**BOTLEY WEST SOLAR FARM
OXFORDSHIRE HOST AUTHORITIES
RESPONSE TO
ANTICIPATED APPLICATION AMENDMENTS TO BE
SUBMITTED TO THE SoS
THURSDAY 16 JULY 2026**

Botley West Solar Farm (EN01014)

AMENDMENTS TO THE APPLICATION ANTICIPATED TO BE SUBMITTED TO THE SOS

Document: Botley West Solar Farm- Residential Visual Amenity- Design Evolution Assessment- July 2026 DRAFT

52 - Denman’s Farm

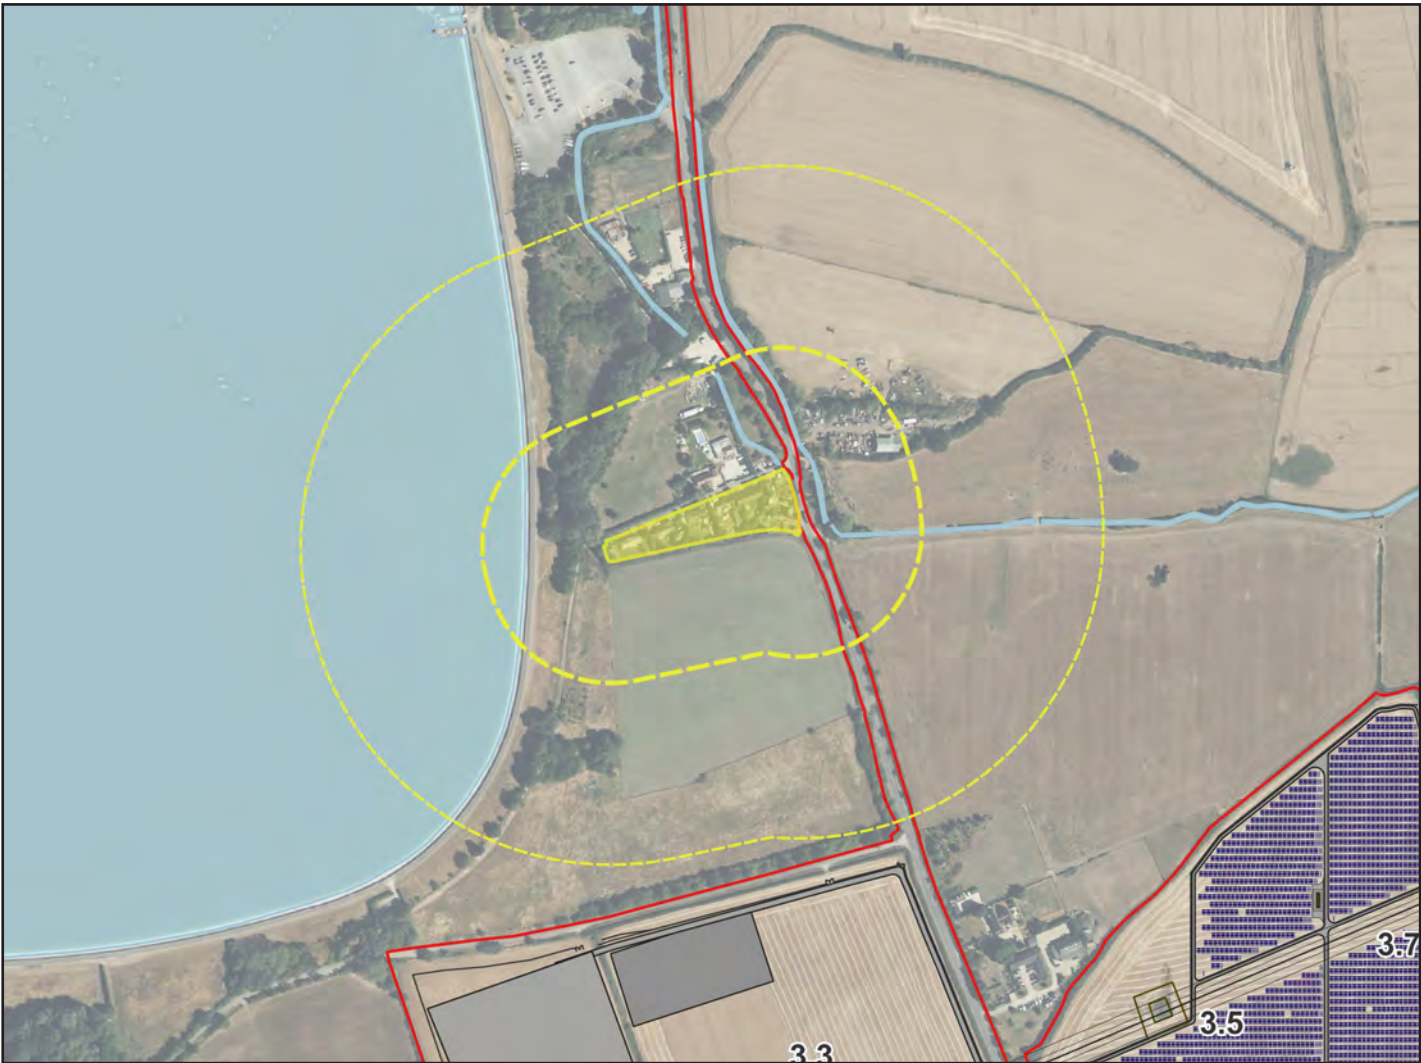
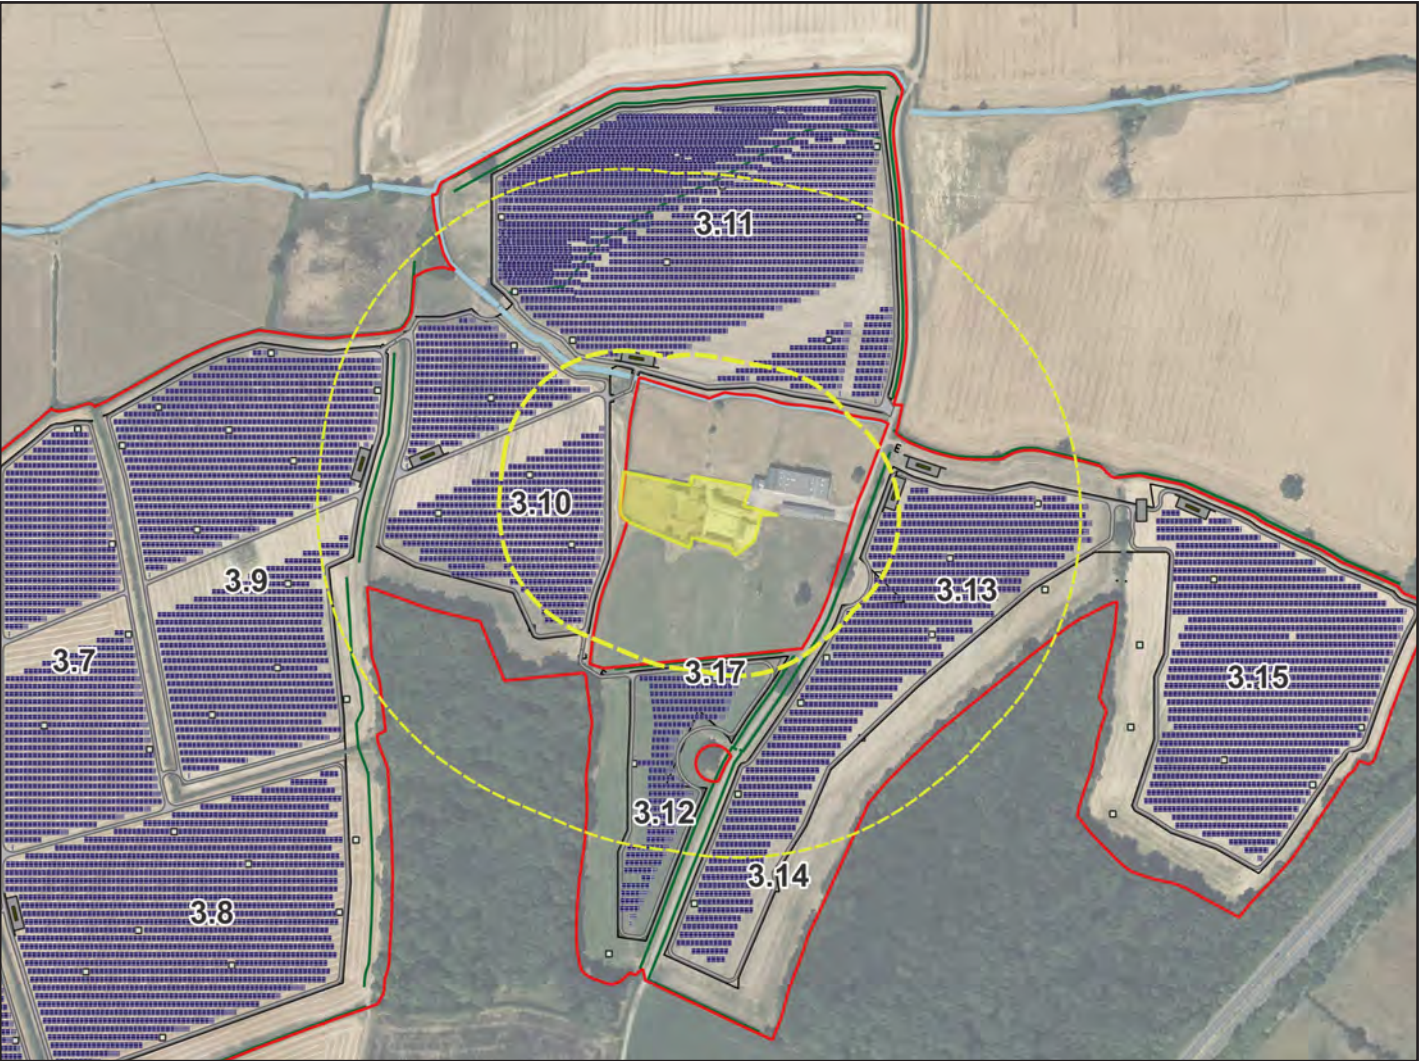
- The concept of Step 4 (Threshold Assessment) is set out in a grey box on page 7, but it does not appear to have been covered within the actual assessment undertaken. Denman’s Farm is mentioned as the only property experiencing a High magnitude of effect (presumably a landowner’s property, and which will be surrounded on all sides), but it appears to be being discounted on the basis of the agreement reached with the applicant, albeit that this should not be part of the consideration of environmental impact. It would appear, for example, that field visits may indicate that the removal of Fields 3.12 and 3.17, or the southerly triangle of Field 3.11 may help reduce this encirclement for any future occupiers of the farm. Has anything been done to help improve the situation here, as well as that for users of the adjacent PROW?
